From: Bloomer, David <David.Bloomer@lancashire.gov.uk>
Sent: 29 September 2017 14:16
To: Stephen Kilmartin
Cc: LHS Customer Service; planning
Subject: app3/2017/0653 Land at Chatburn Rd , Clitheroe

The proposed site for this development has had an previously considered and approved (2013/0981) which was for a larger development. Consequently I would be raising no objection to the principle of the development in this location but there are a number of issues which will need to be resolved.

DRAWING NUMBER
016P/01

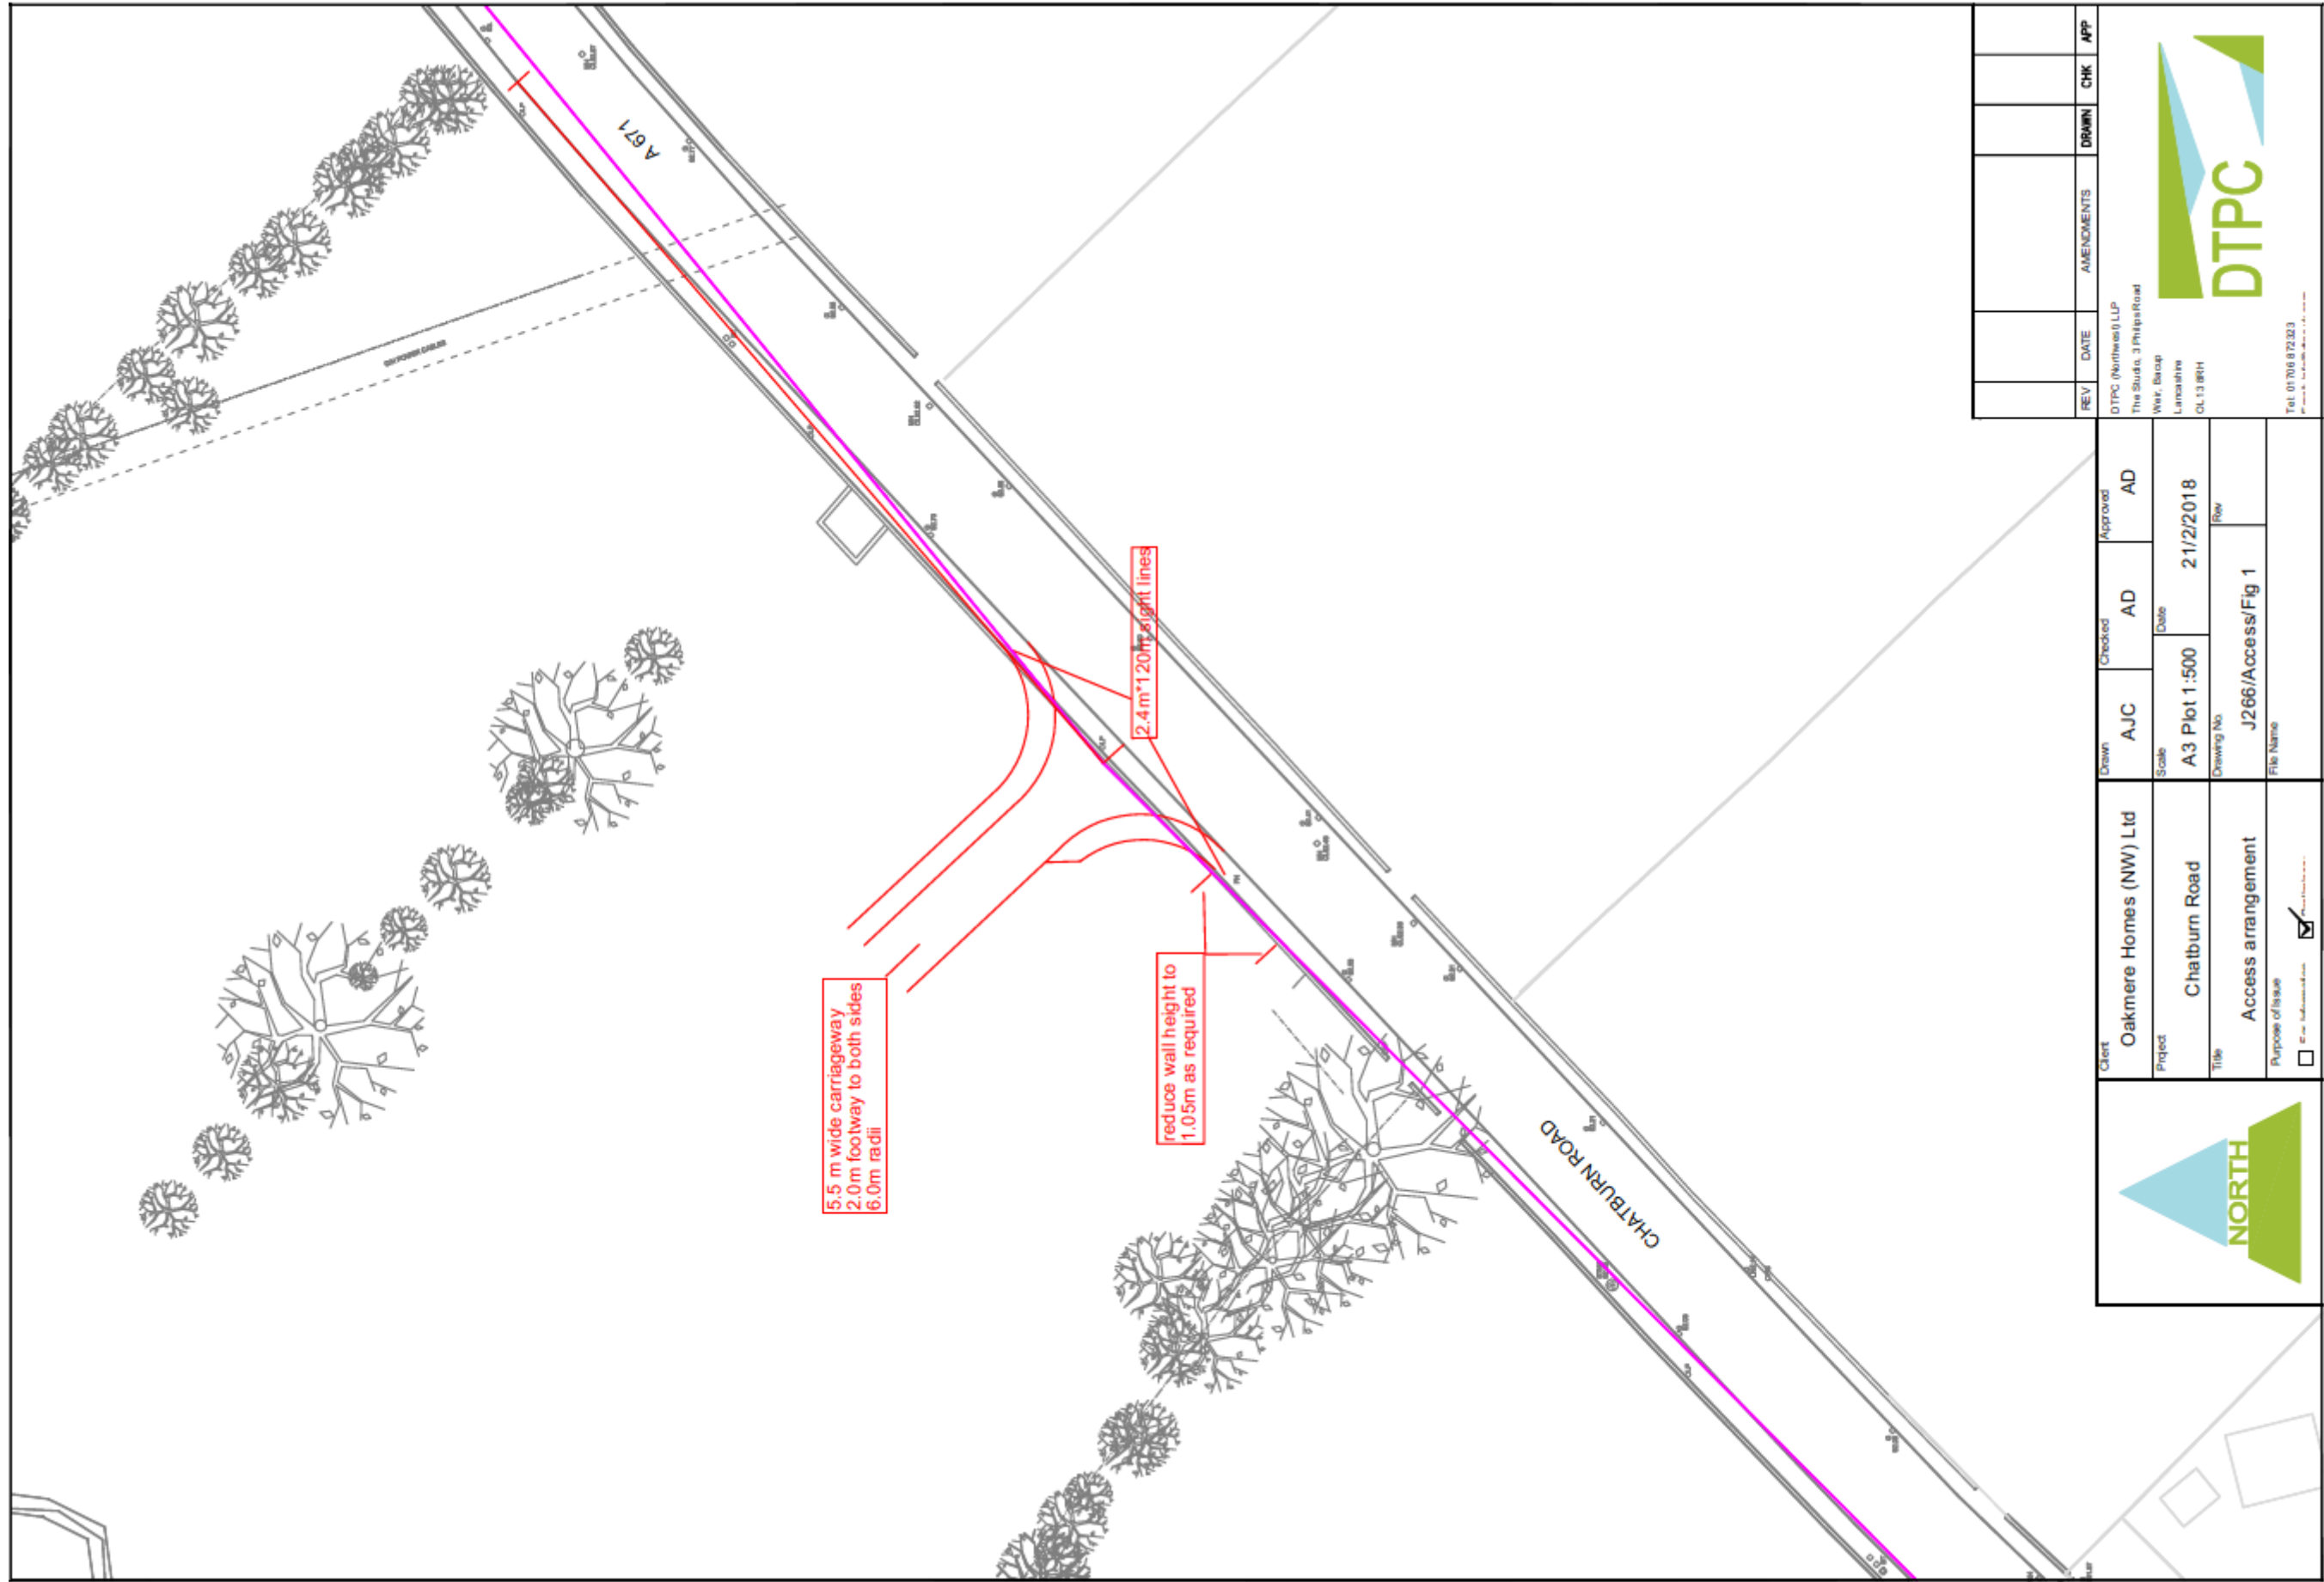
- 1 The main spine road off Chatburn Road should have a 2m footway on both sides along its full length and including the turning head at unit 20
- 2 All other cul-de sacs should have a combination of footways and service strips along both sides.
- 3 Any driveway parking should not encroach onto or over either service strips or footways
- 4 The proposed footbridge will remain in private ownership. Also it looks too narrow to accommodate a dog walking alongside a pedestrian (Min 1100mm)
- 5 The surface water drainage proposed 2x900mm drainage pipes prior to discharge. Unless these are considered acceptable and adopted by UU they would not be acceptable within a carriageway put forward for adoption.
